# Rezoning Transportation Analysis

Petition Number: #2022-105

General Location Identifier: 05549113, 05549114, 05549115, 05549128

Date	Description
11-28-22	First Review (PM)
12-22-22	Second Review (DR)
2-22-23	Third Review (JP)
12-19-23	Fourth Review (IW)
04-09-24	Fifth Review (IW)
04-22-24	Sixth Review (IW)

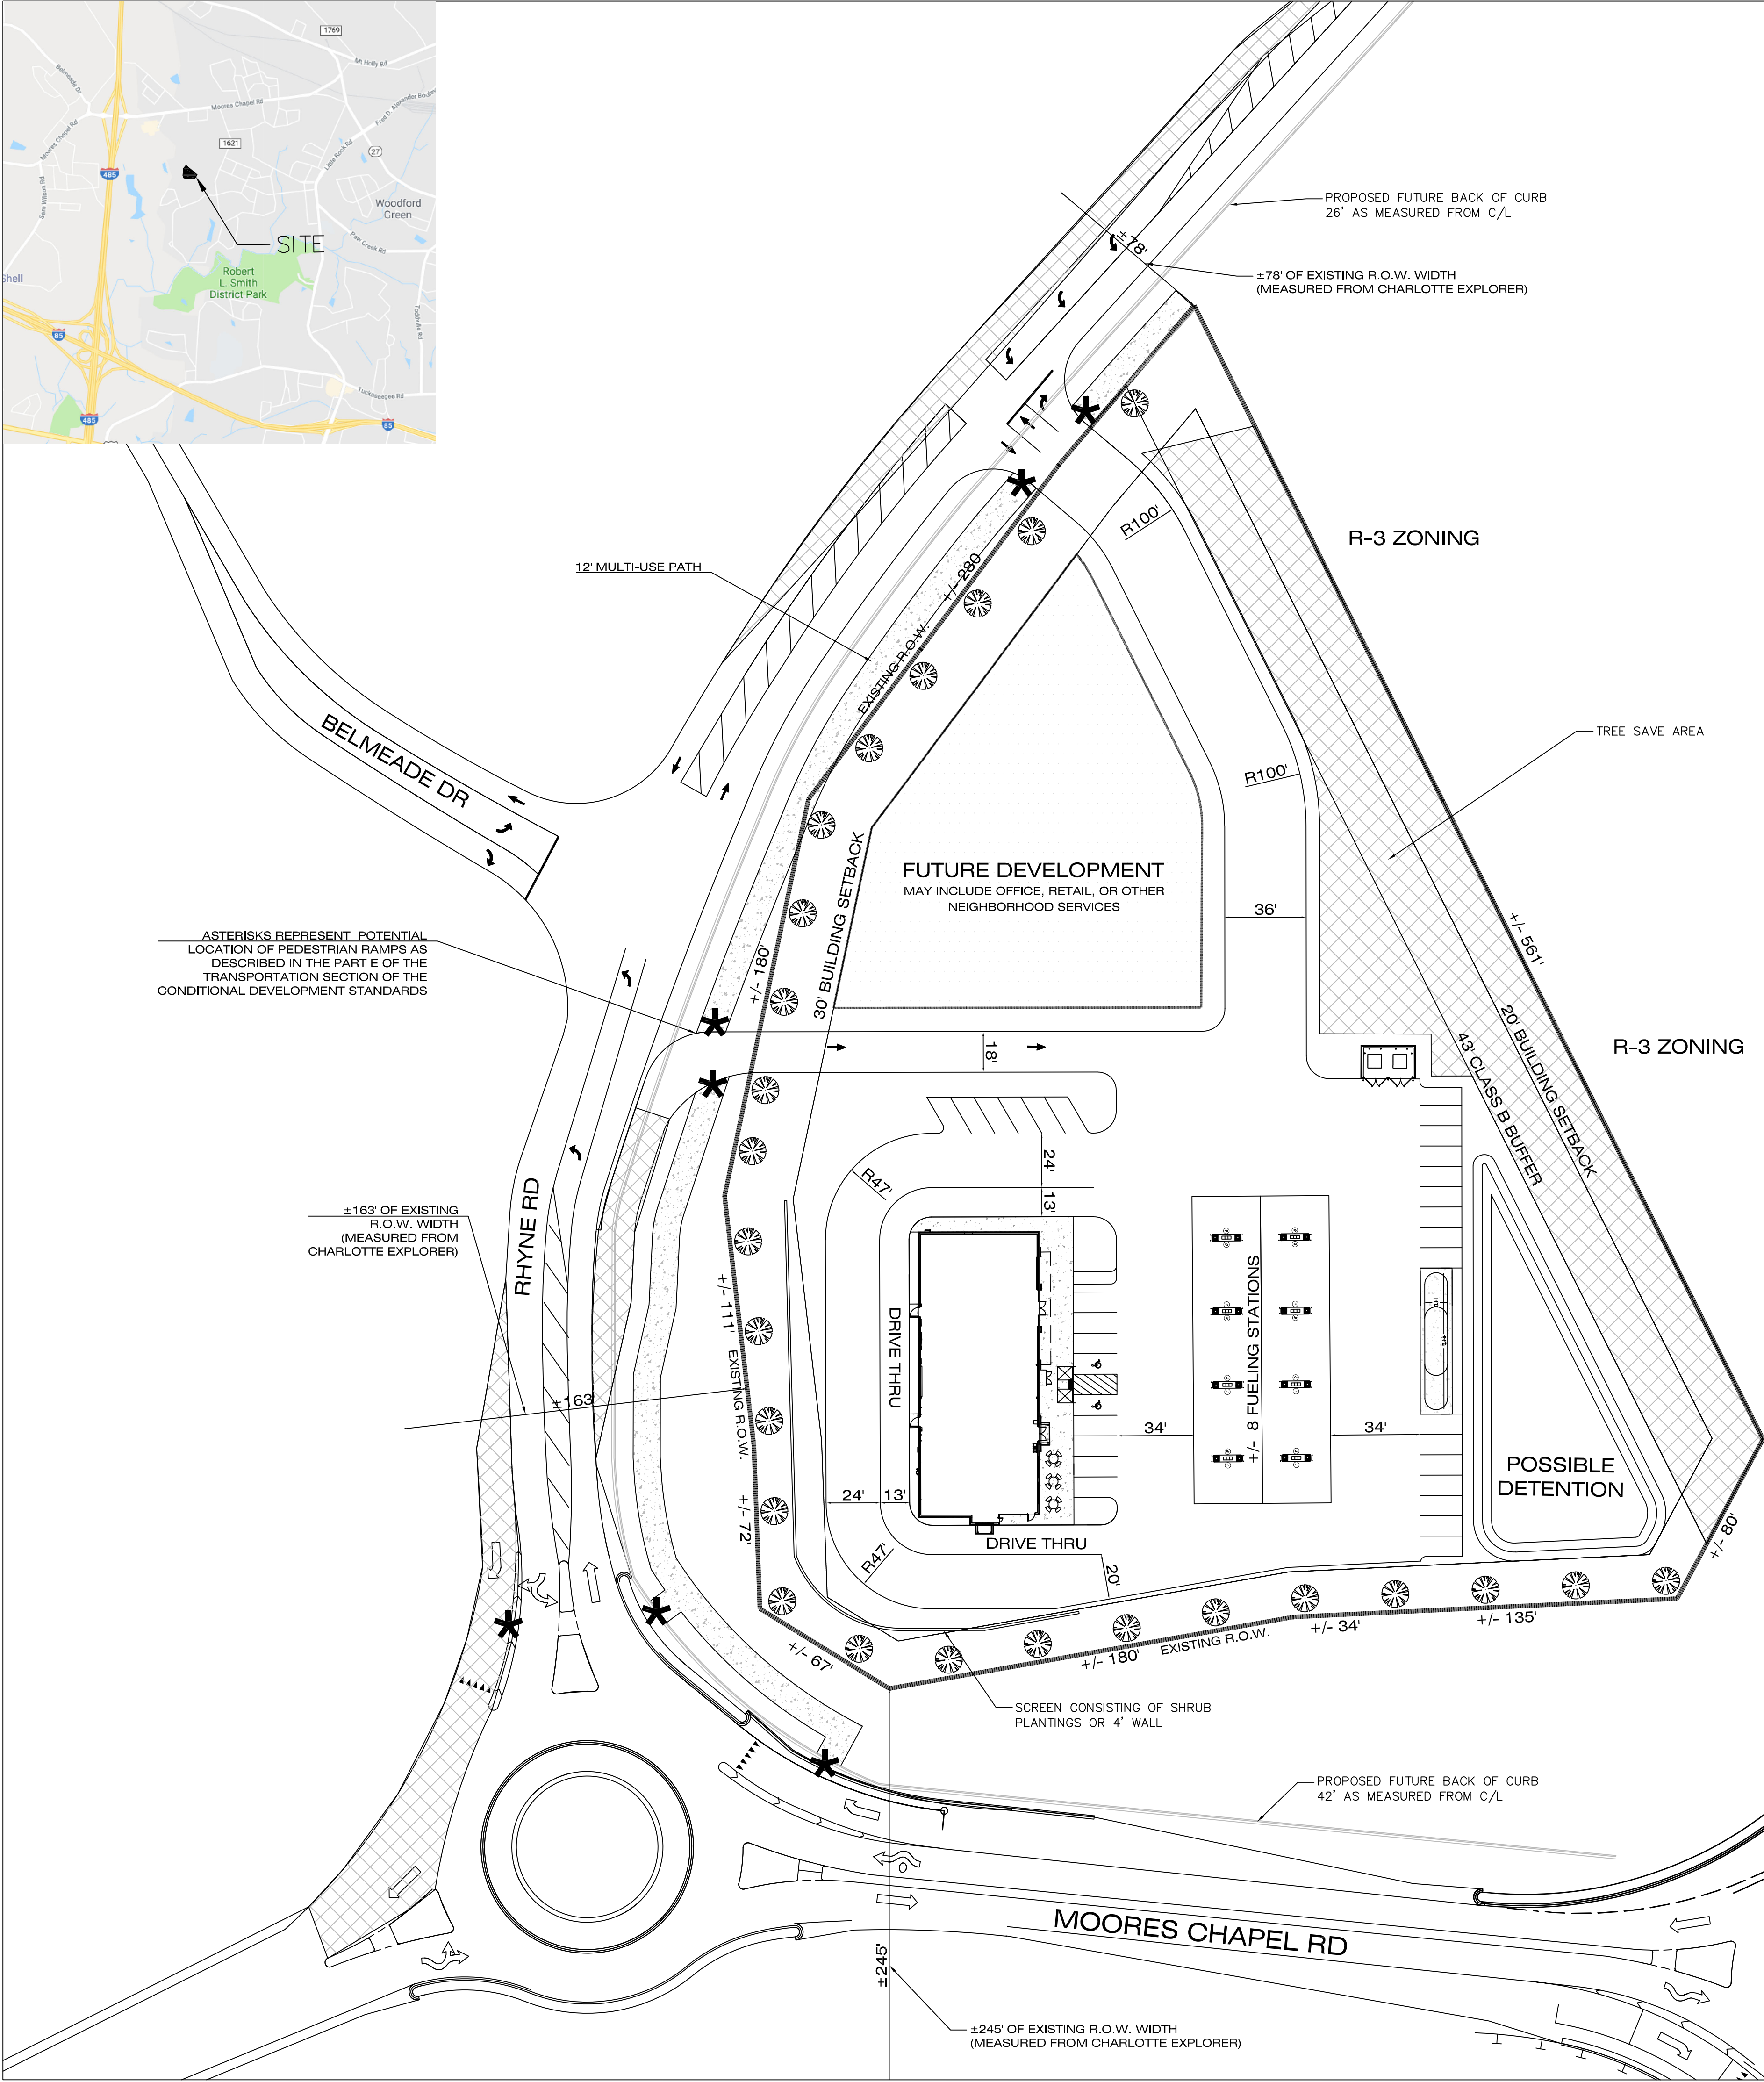
4. **Outstanding Comment** Revise site plan and conditional note(s) to provide 12-foot multi-use path and 8-foot planting strip along all public road frontages (Moores Chapel Road, Rhyne Road, Belmeade

Drive). Revise the ramp locations and conditional note Transportation Note E to include the additional ramps that will be required. Provide SUE located 2-feet behind sidewalk if located outside of the ROW. Add conditional note to coordinate Control of Access Break with NCDOT for proposed multi-use path along

**Clarifying Comment from 4/24/2024:** Sidewalk facilities are required per City ordinance for all public road frontages, including Moores Chapel Road. It is understood that the previous tree save parcel is no longer included in the petition and improvements are not required for that parcel.

- Outstanding Comment** Revise site plan and conditional notes to provide curb and gutter along the public roads that front the proposed tree save parcel. The minimum distance to the back of curb and gutter is 19-feet from the centerline of Rhyne Road and 30-feet from the centerline of Moores Chapel Road.

**Clarifying Comment from 4/24/2024:** Curb and gutter is required per City ordinance for all public road frontages, including Moores Chapel Road. It is understood that the previous tree save parcel is no longer included in the petition and improvements are not required for that parcel.
